Ribble Valley Borough Council
Council Offices
Church Walk,
Clitheroe
Lancashire
BB7 2RA

Phone: 0300 123 6780
Email: developeras@lancashire.gov.uk
Your ref: 3/2025/0647
Our ref: 3/2025/0647/HDC/KW
Date: 06 November 2025

Location: Clitheroe Football Club Shawbridge Street Clitheroe BB7 1LZ
Proposal: Proposed demolition of existing clubhouse and construction of new clubhouse and community hub.
Grid Ref: 374720 441735

Client: Clitheroe Football Club Ltd.		
Project: Proposed New Clubhouse & Community Hub Shawbridge Pendle Road Clitheroe		
Dwg title: Proposed Site Plan		
Scale @ A3: 1:500	Date: 04.08.25	Drawn by: PD
Drawing no. 1720 - 102	Rev. -

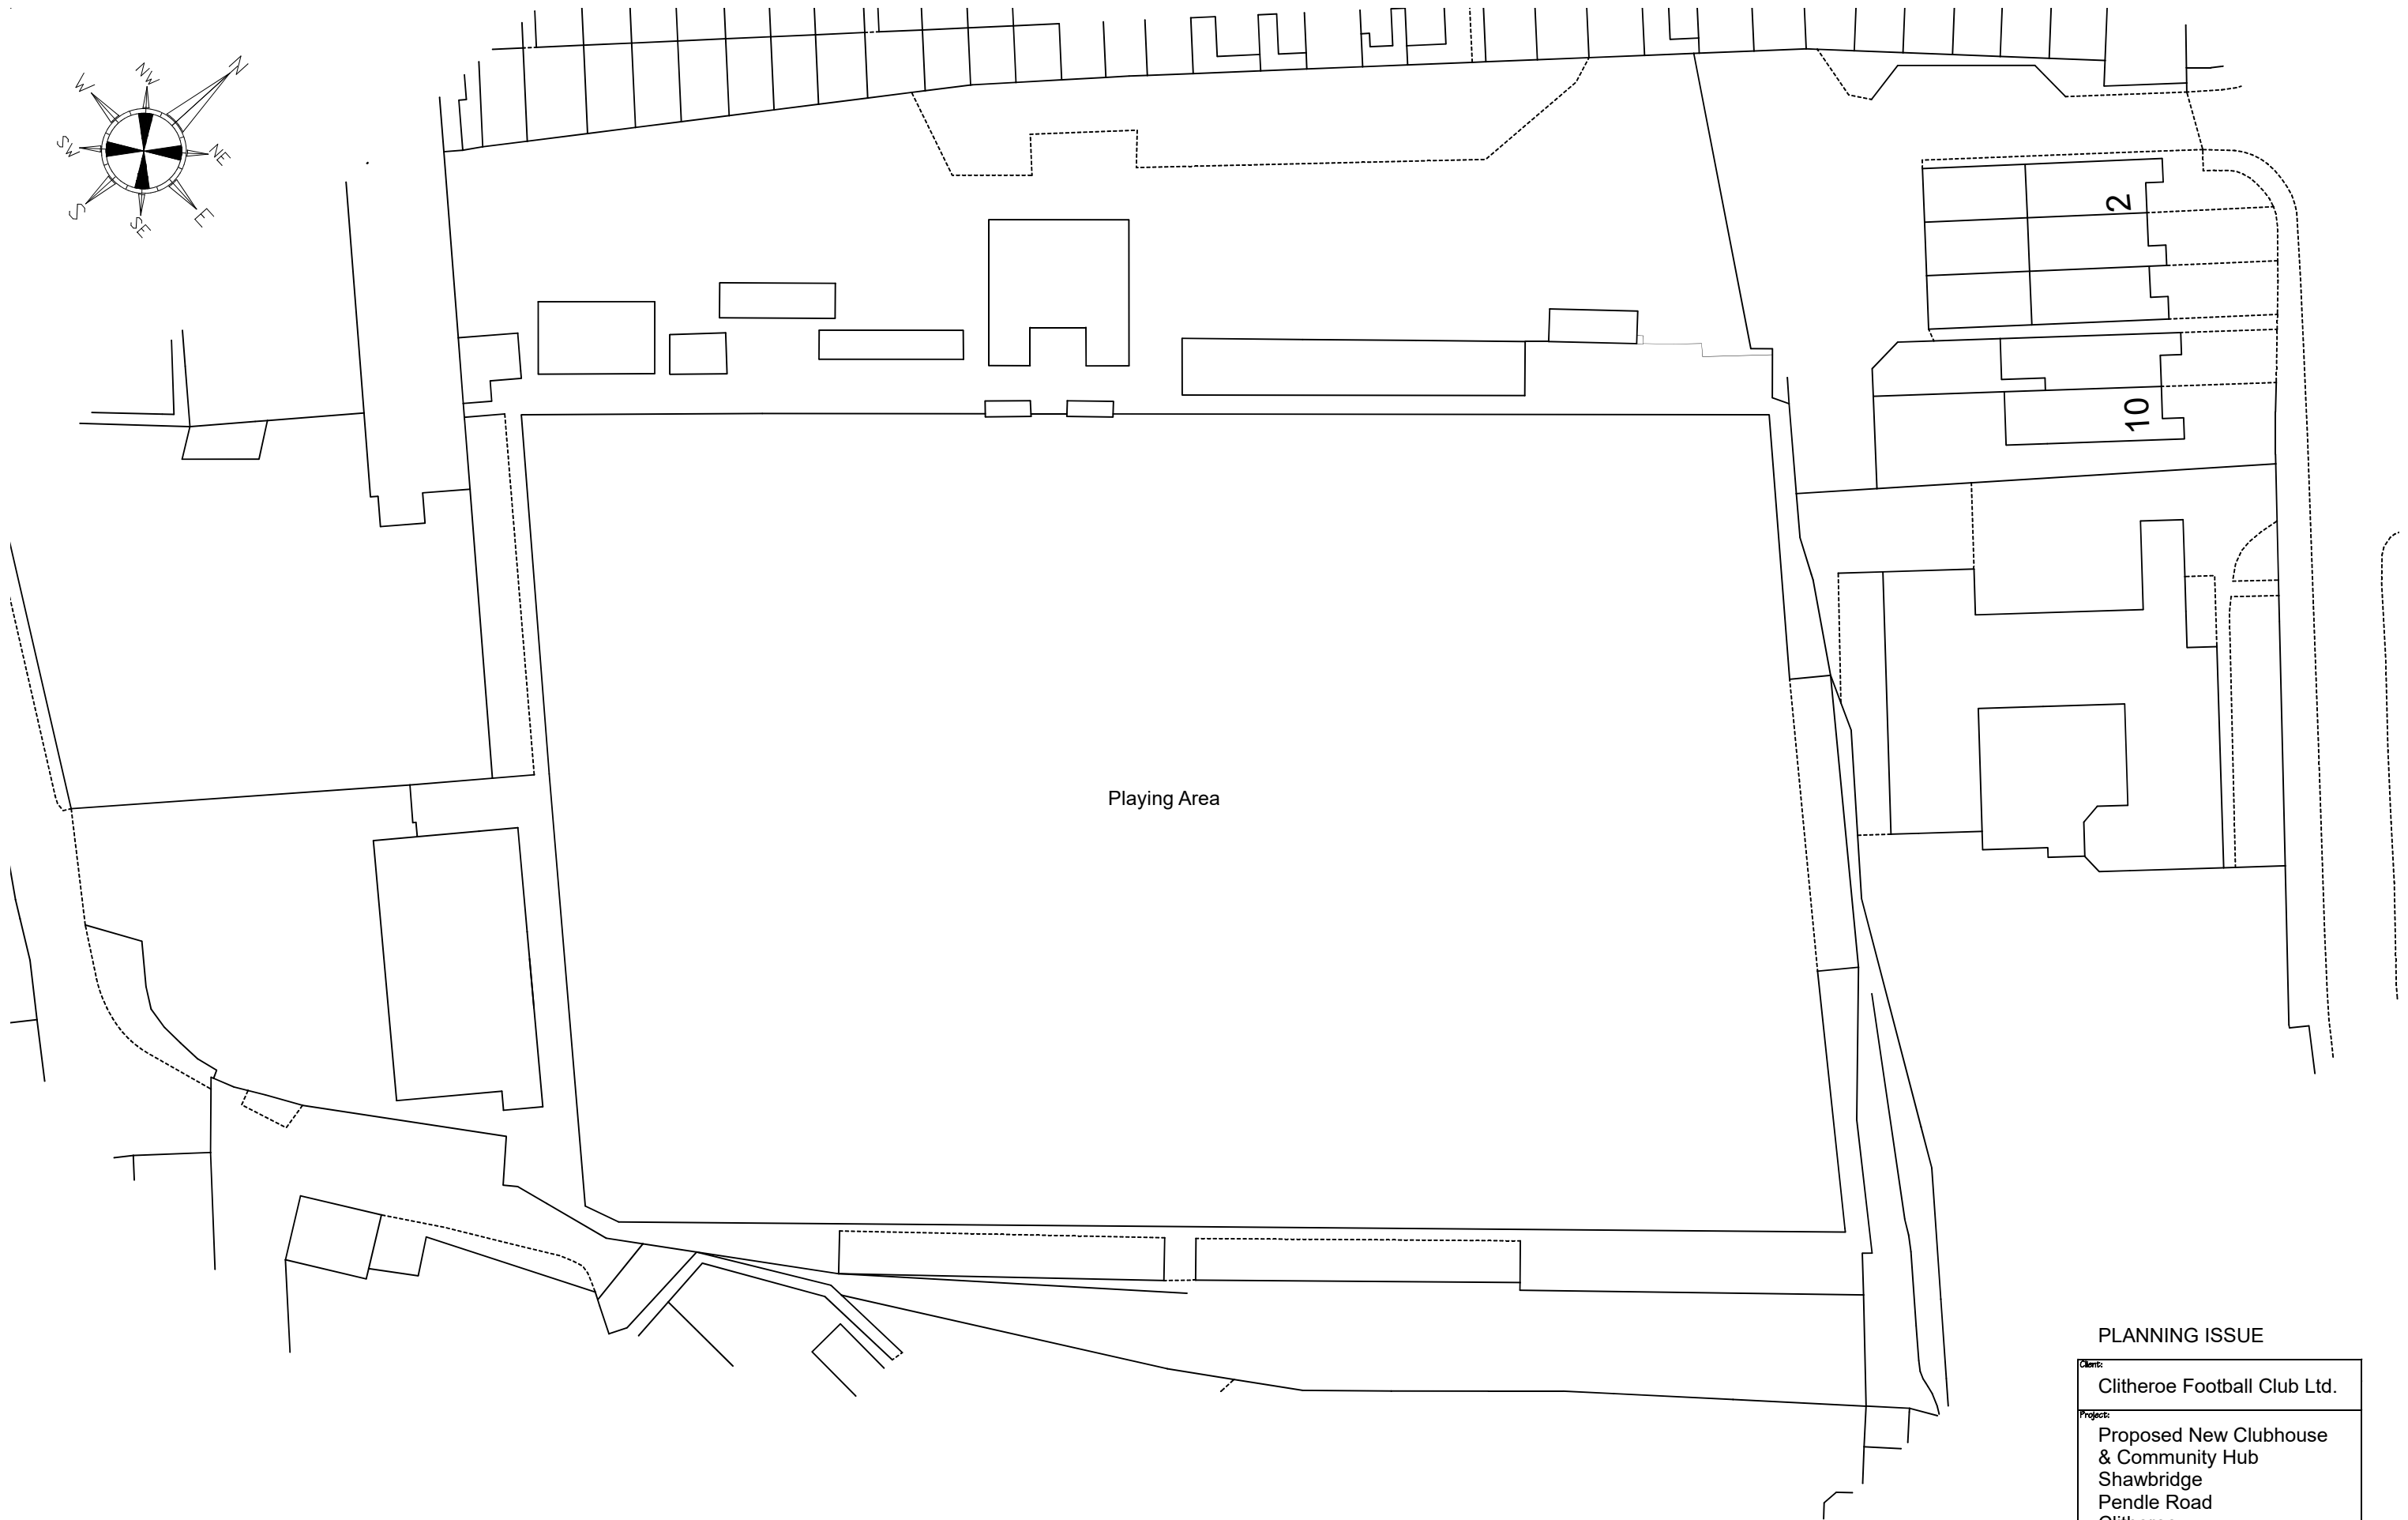
The LHA have reviewed drawing number 1720 - 102 titled "Proposed Site Plan" and are aware that the site accesses, on Bright Street and Shawbridge Street, will remain unaltered following the proposal. While the LHA acknowledges the established use of these access points, concerns remain regarding the insufficient access width, which may

constrain vehicle movements and compromise safety, along side the absence of dedicated pedestrian infrastructure, increasing potential conflict between vehicles and pedestrians. These issues may affect the safe and efficient operation of the site, particularly during peak activity periods.
